EPC STORMWATER REVIEW COMMENTS
IN ORANGE BOXES WITH BLACK TEXT

SADDLEHORN RANCH - FILING 4

CONSTRUCTION DOCUMENTS

SADDLEHORN RANCH -
FILING 4
COVER SHEET

SADDLEHORN RANCH - FILING 4
 TYPICAL SECTIONS
 SHEET 3 OF 11
 JOB NO. 25142.06

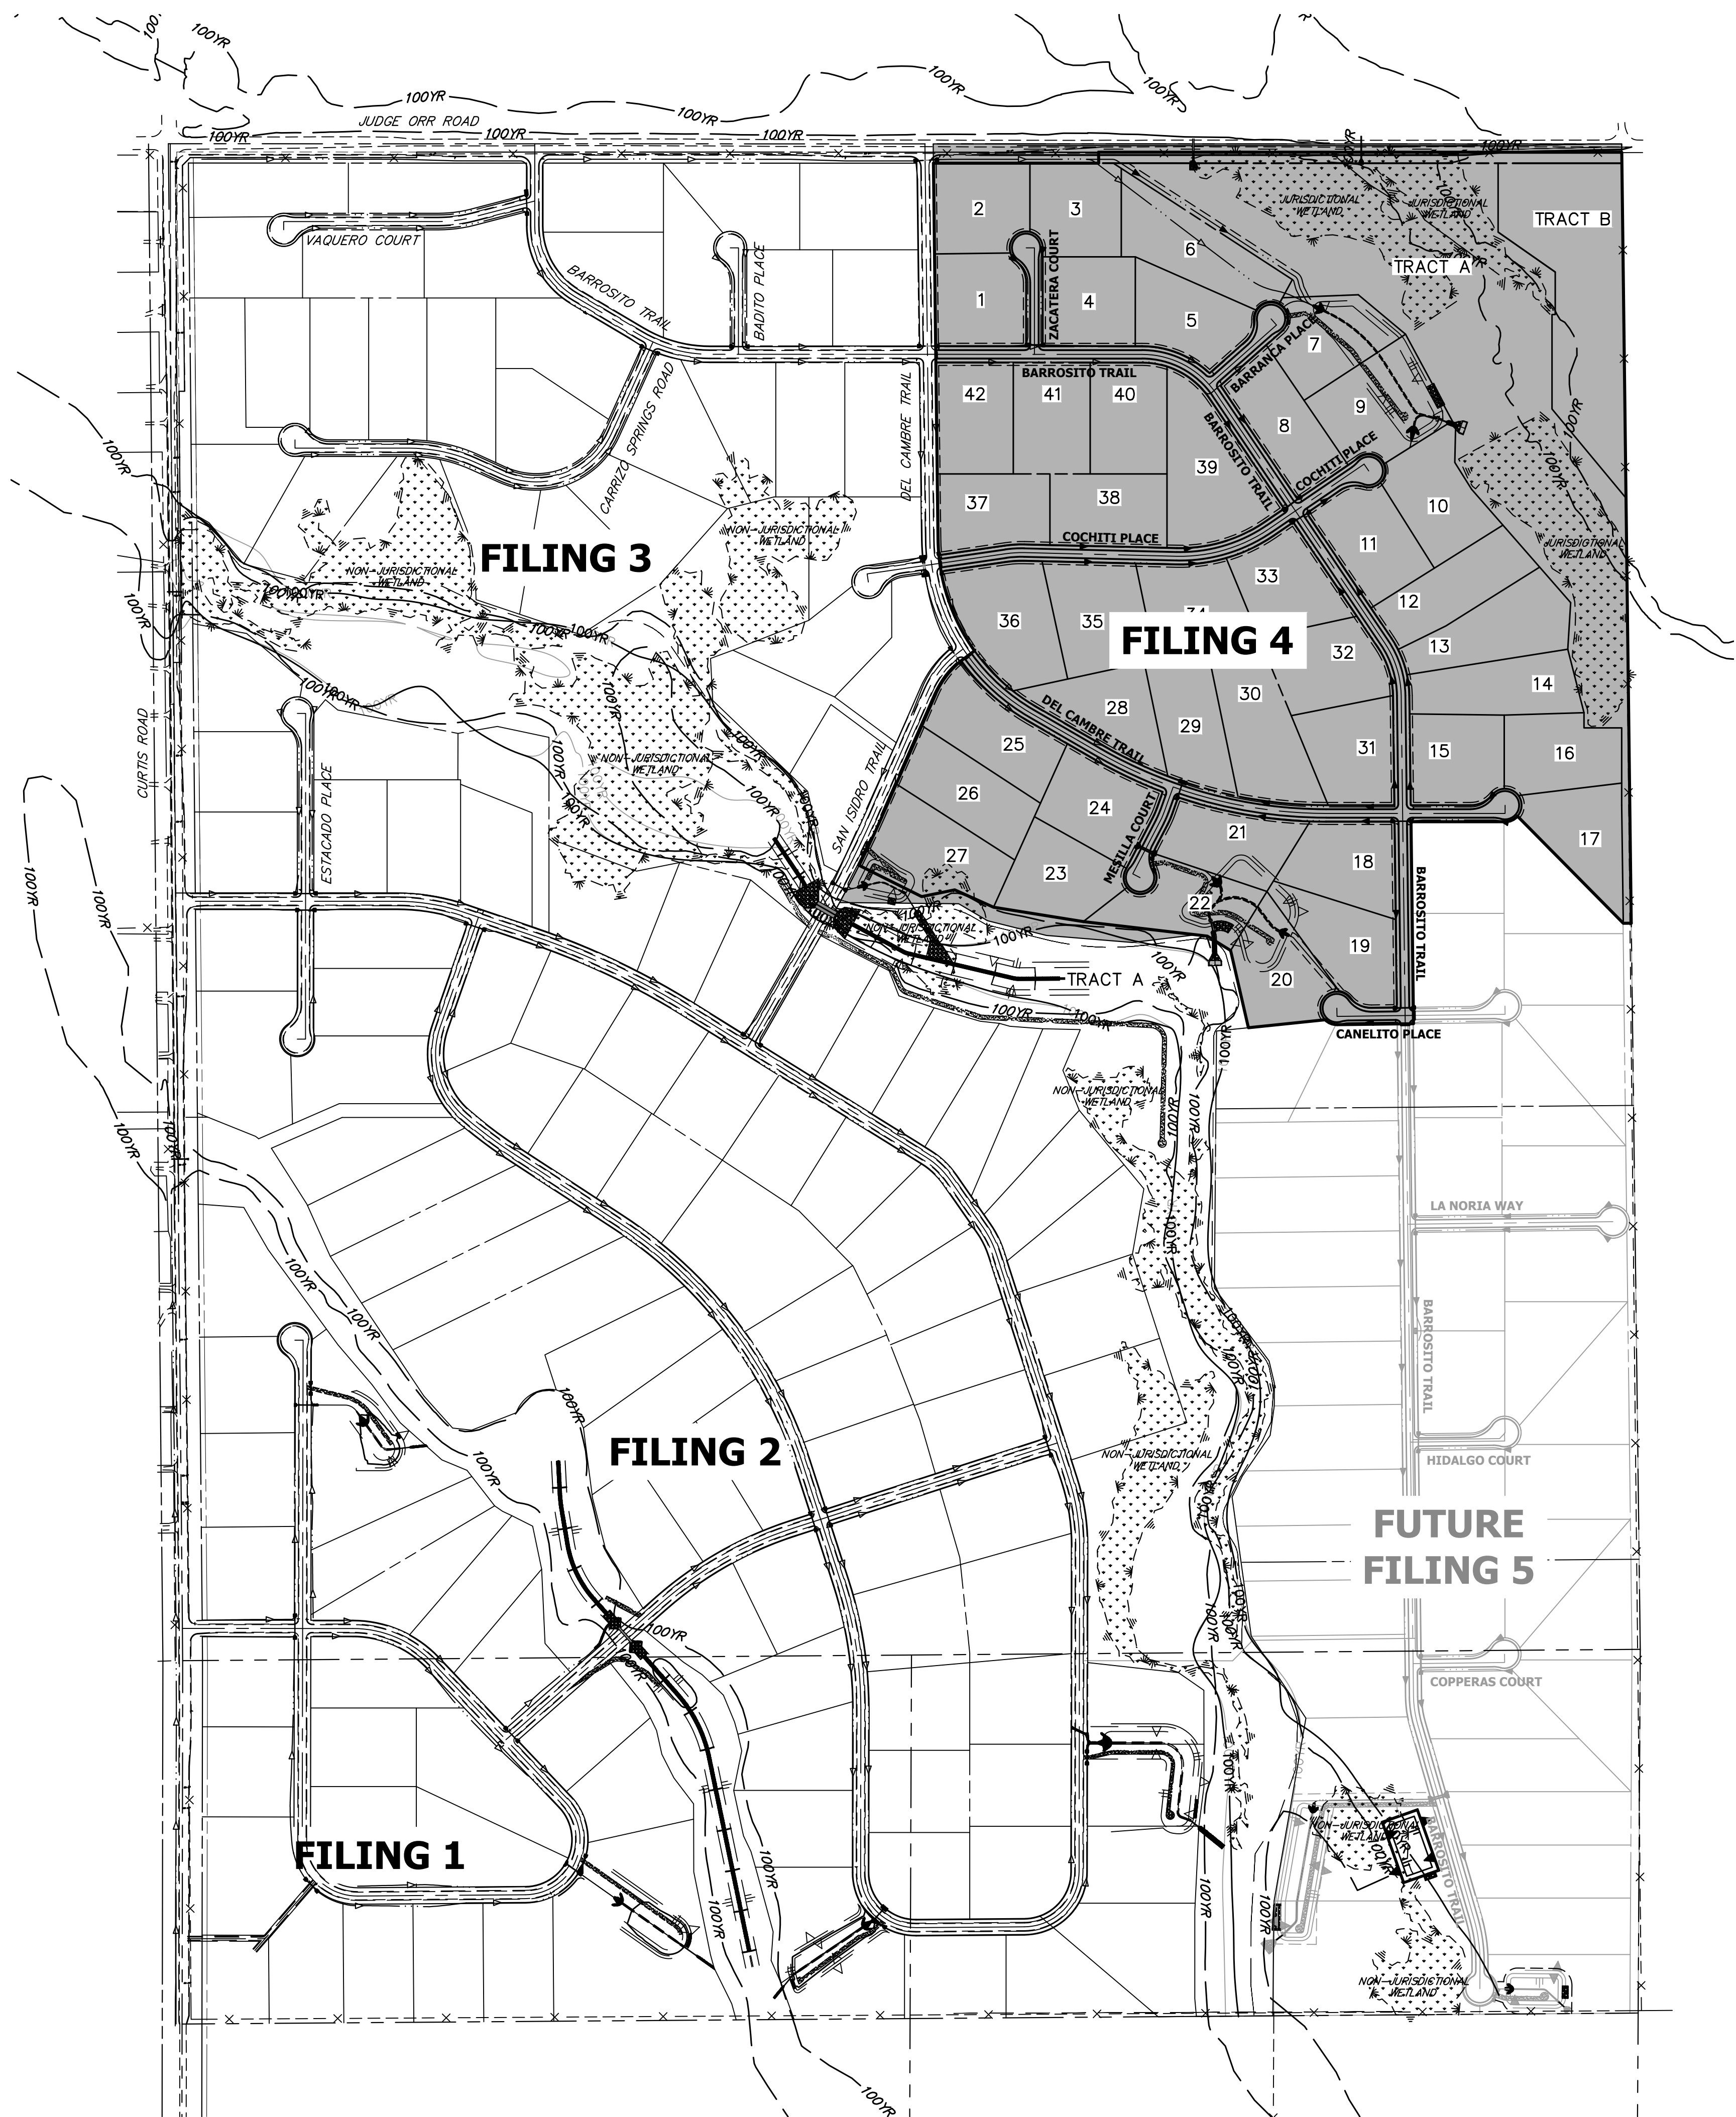
Section B-B on the GEC plans show these widths as 9' and 12' respectively. The depth is listed as 3' on the GEC Plans. Verify the dimensions and update so both the CDs and GEC Plans match.

SWALE SECTIONS HAVE BEEN FIXED
